NC DEPARTMENT OF
**HEALTH AND
HUMAN SERVICES**

July 22, 2024

RE: Jersey Mike's Subs
NC Hwy 210
Lillington, NC 28546

This letter acknowledges review of the plan for the above referenced establishment. The revised plans dated 07/16/24, application and email correspondence are approved with the following conditions:

A4.0

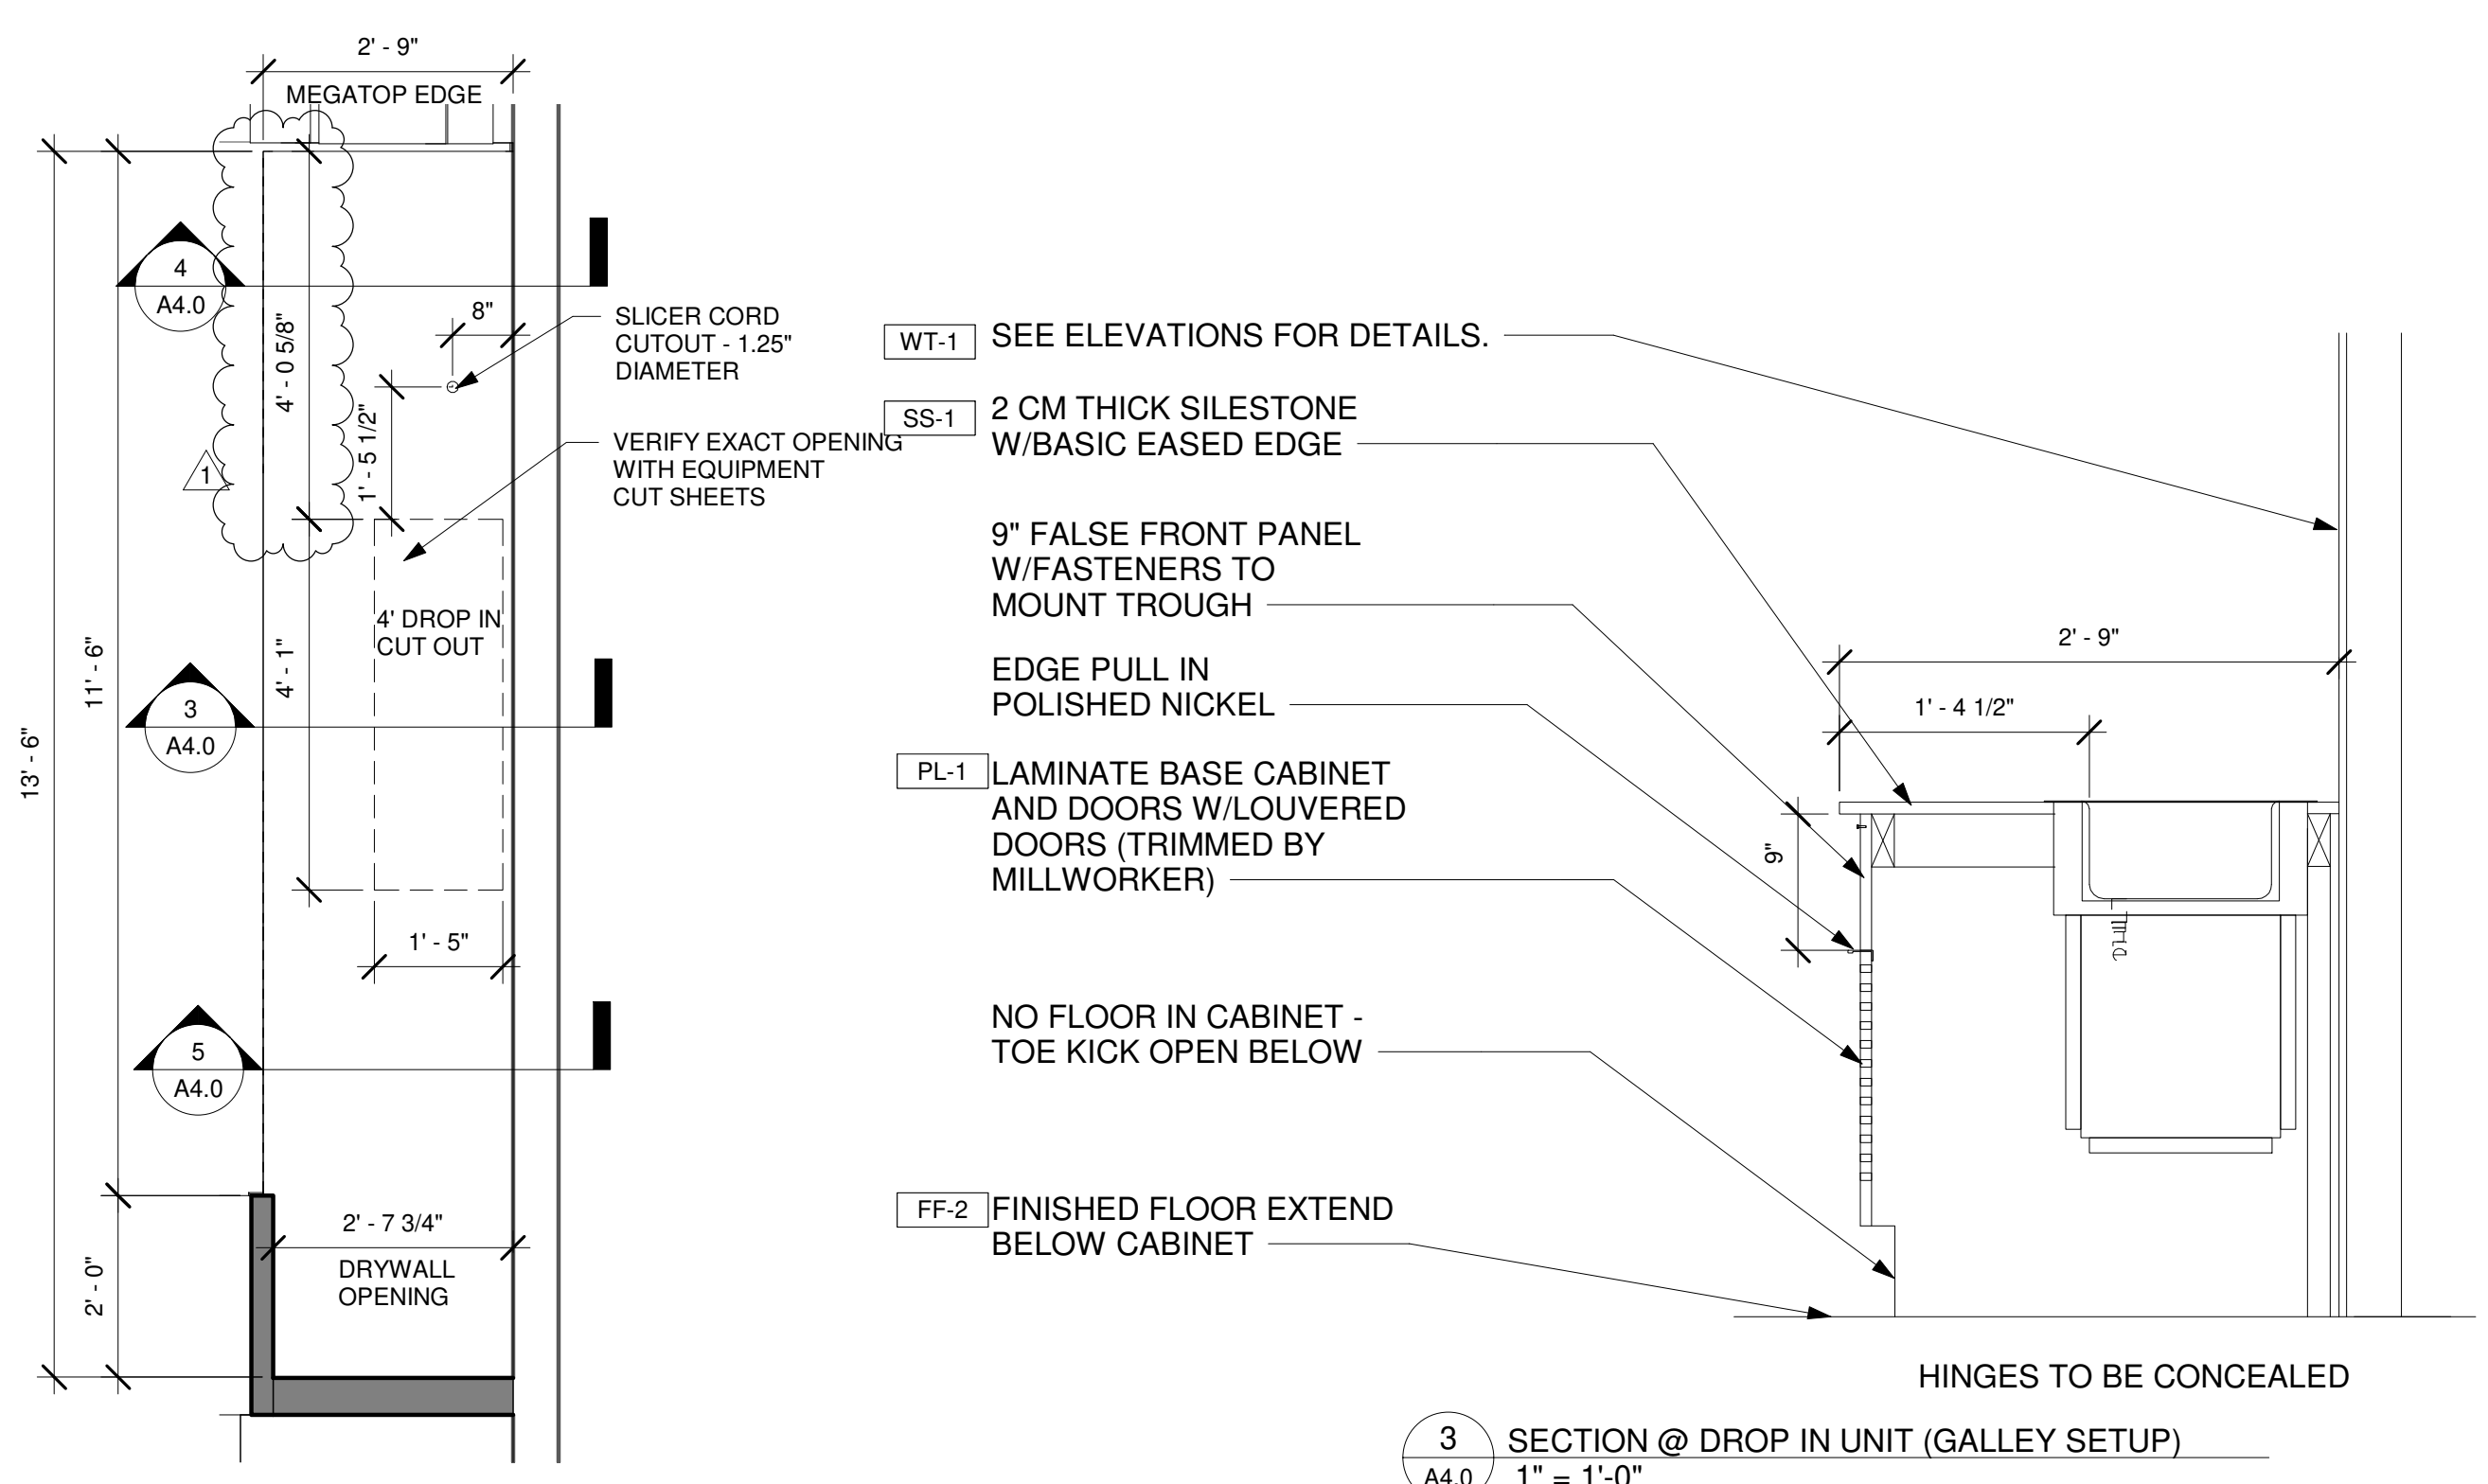
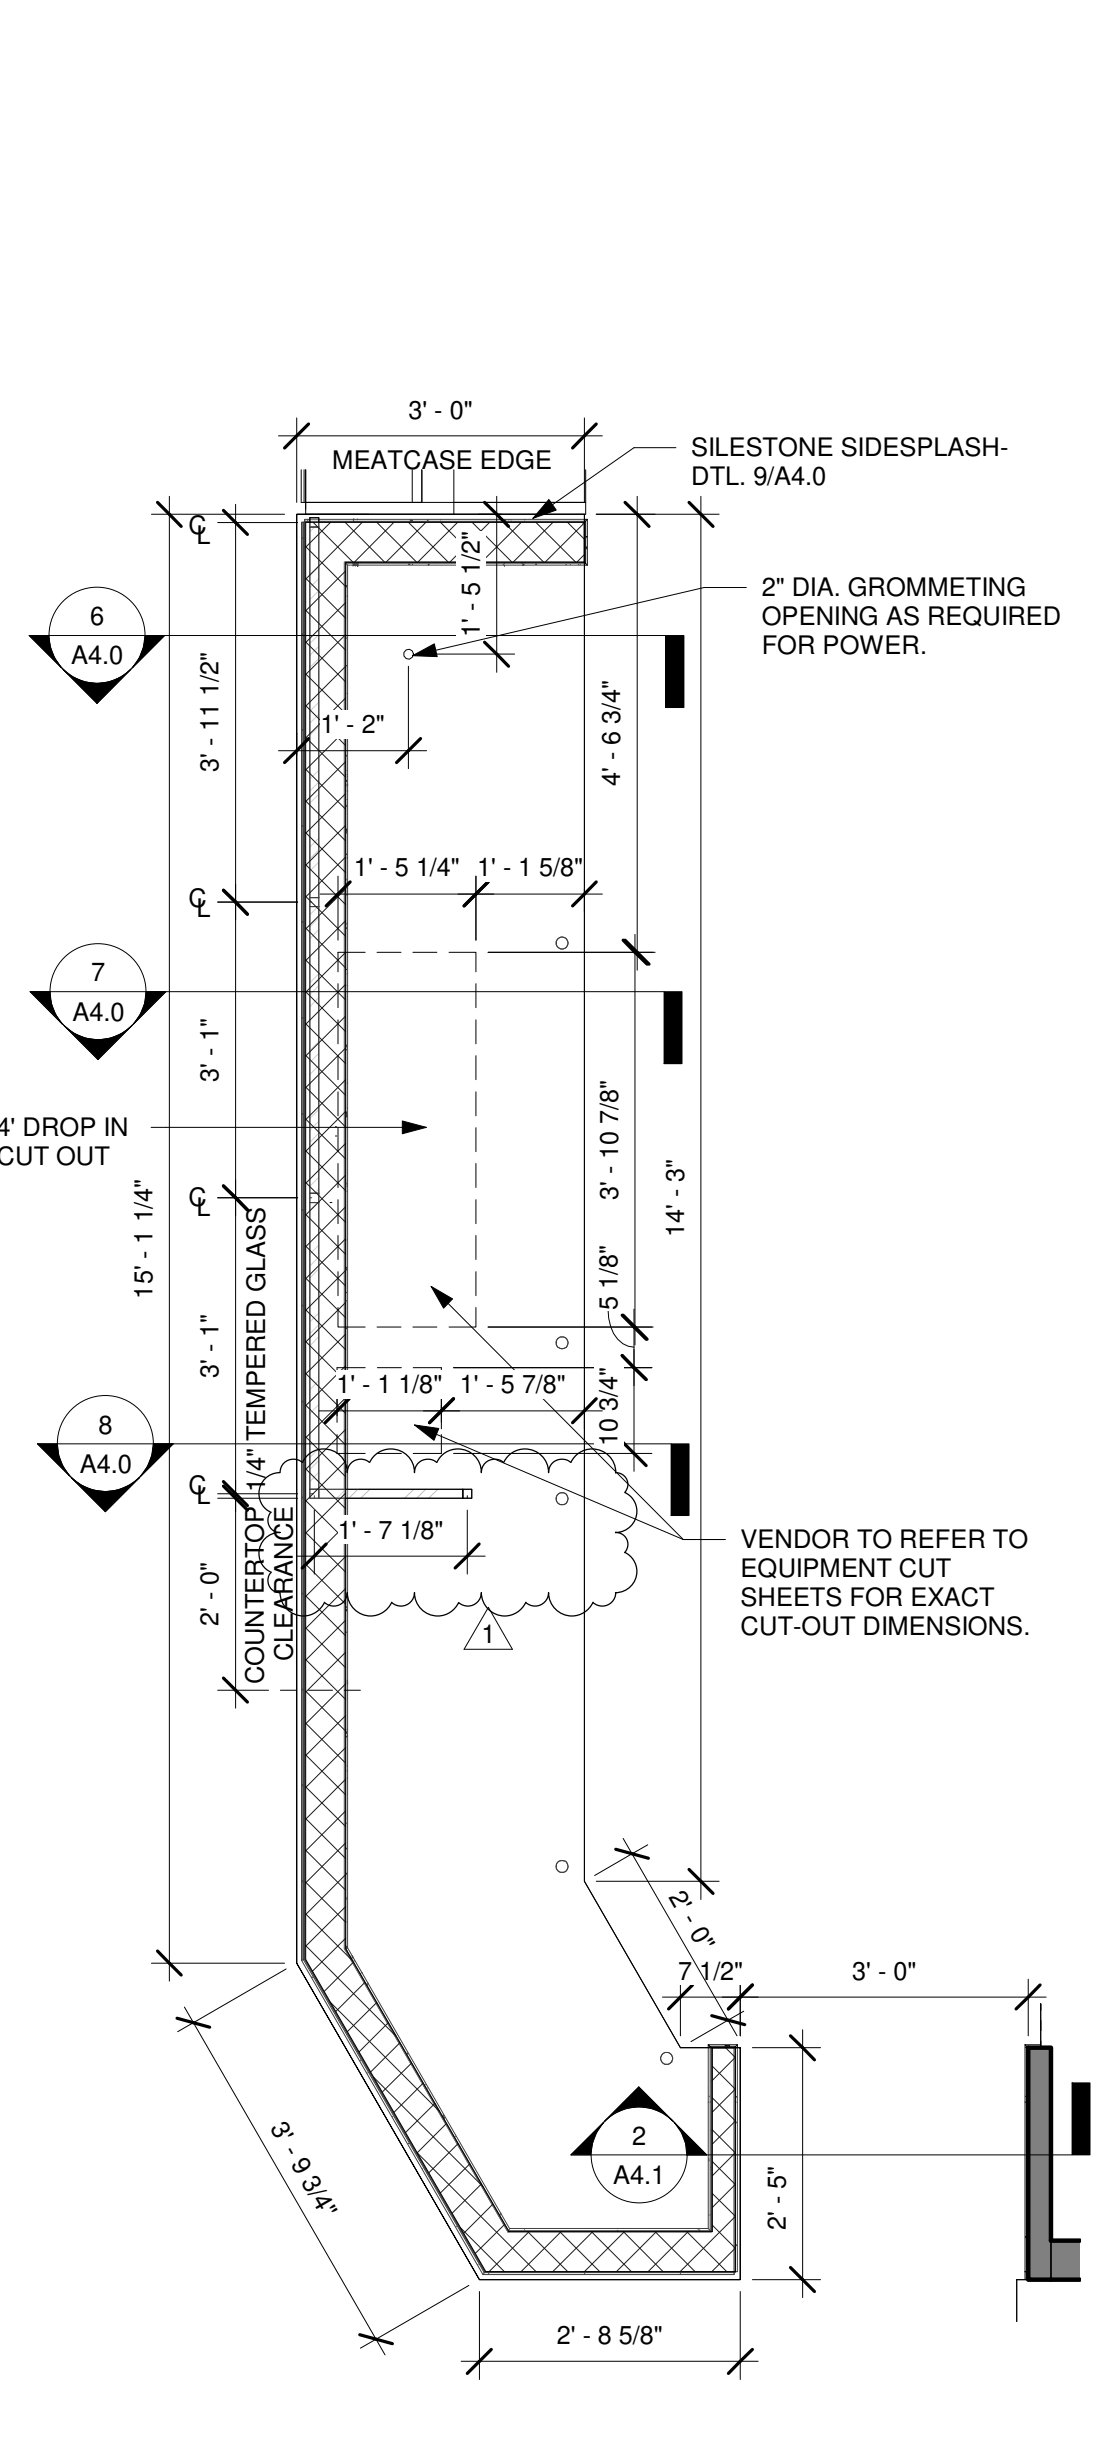
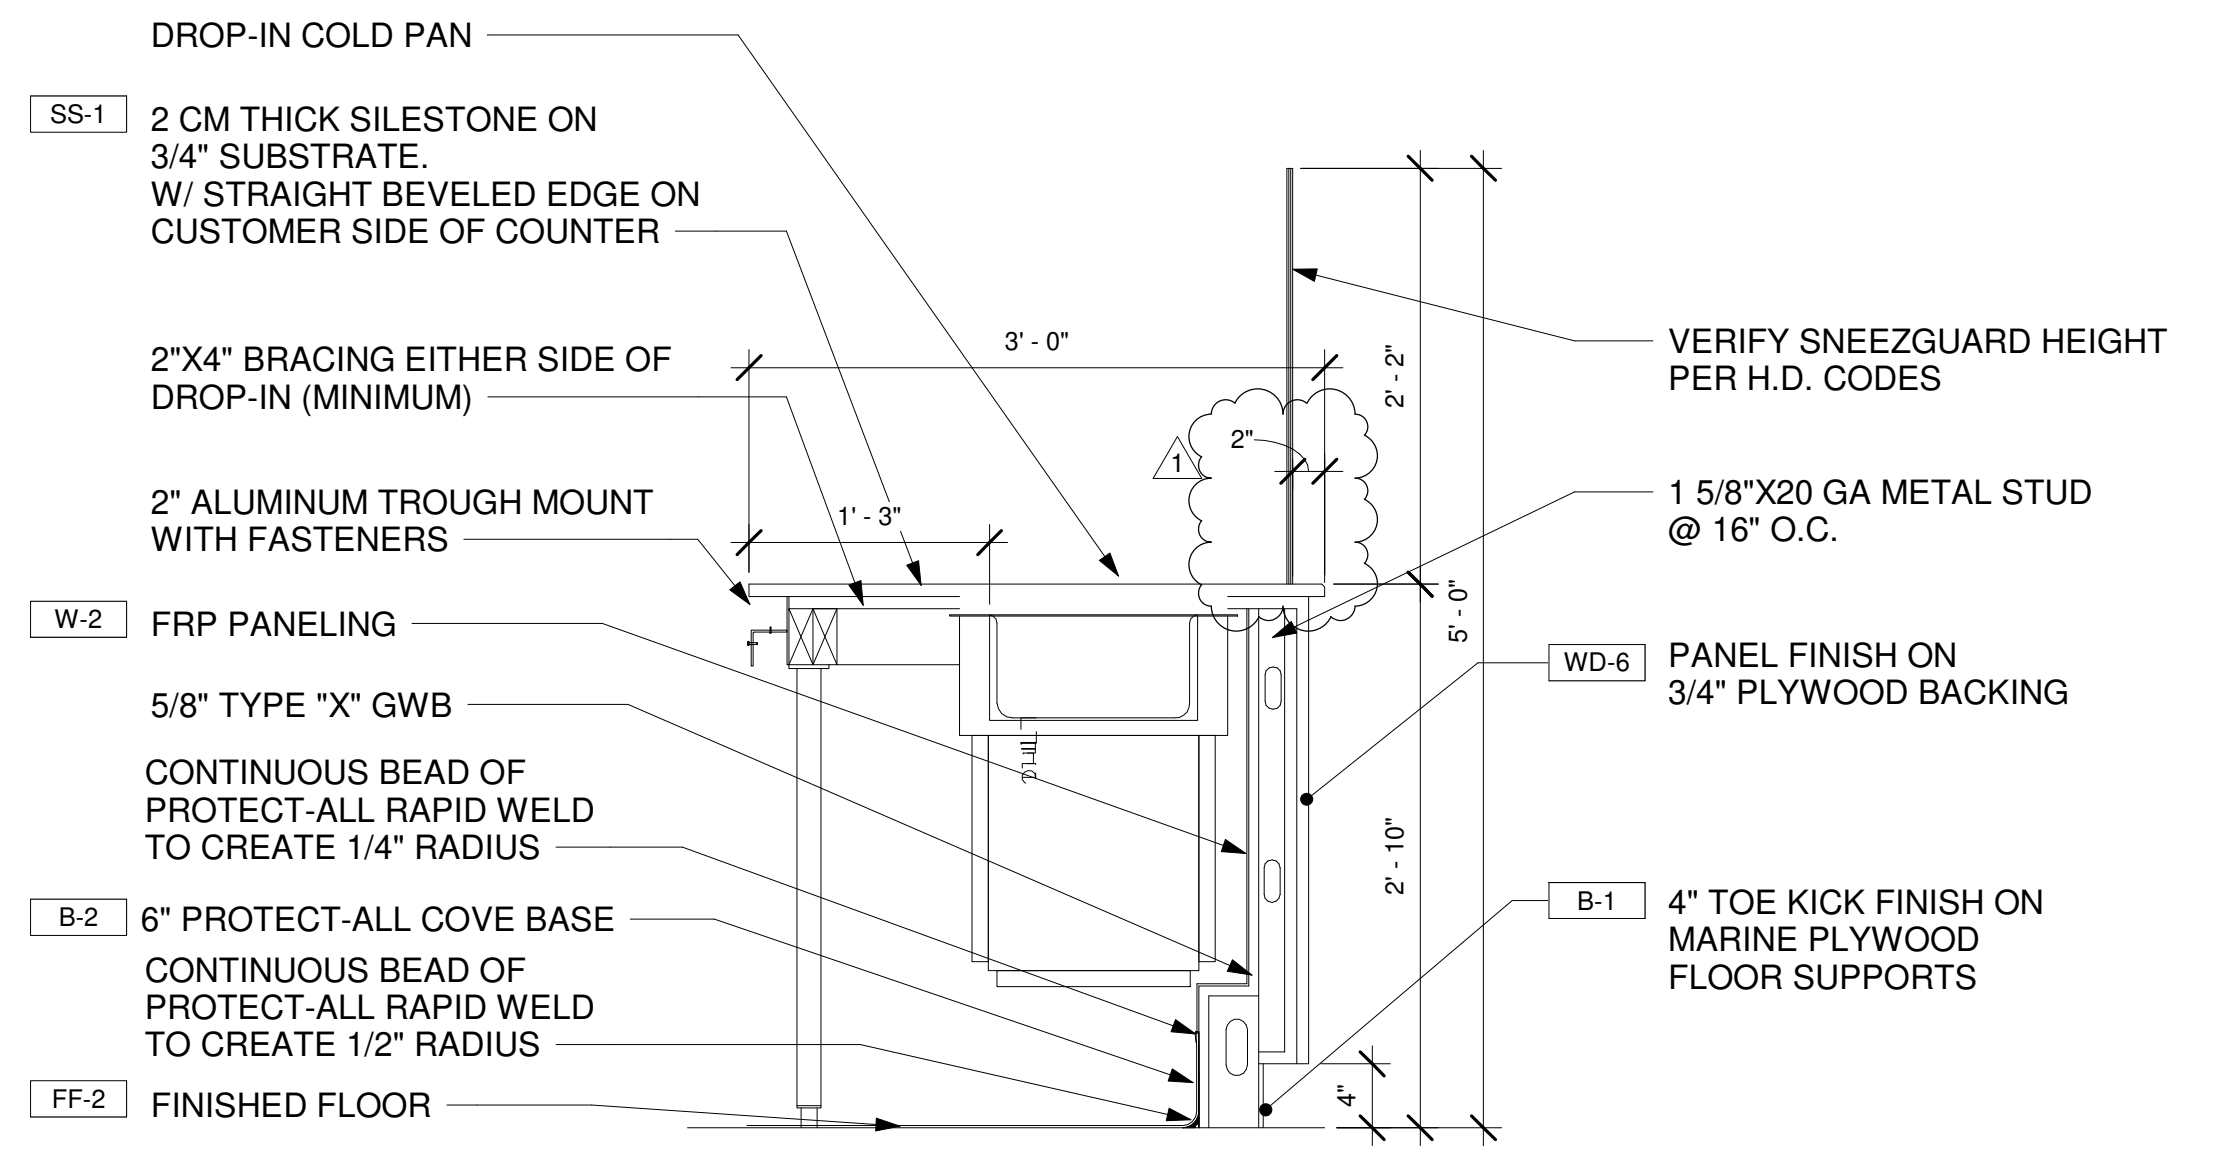
- b. The sneeze guard(s) will be installed 5' at finished floor and shall extend between the bacon warmer and POS as shown on revised plan sheet A4.0 and EQ1.
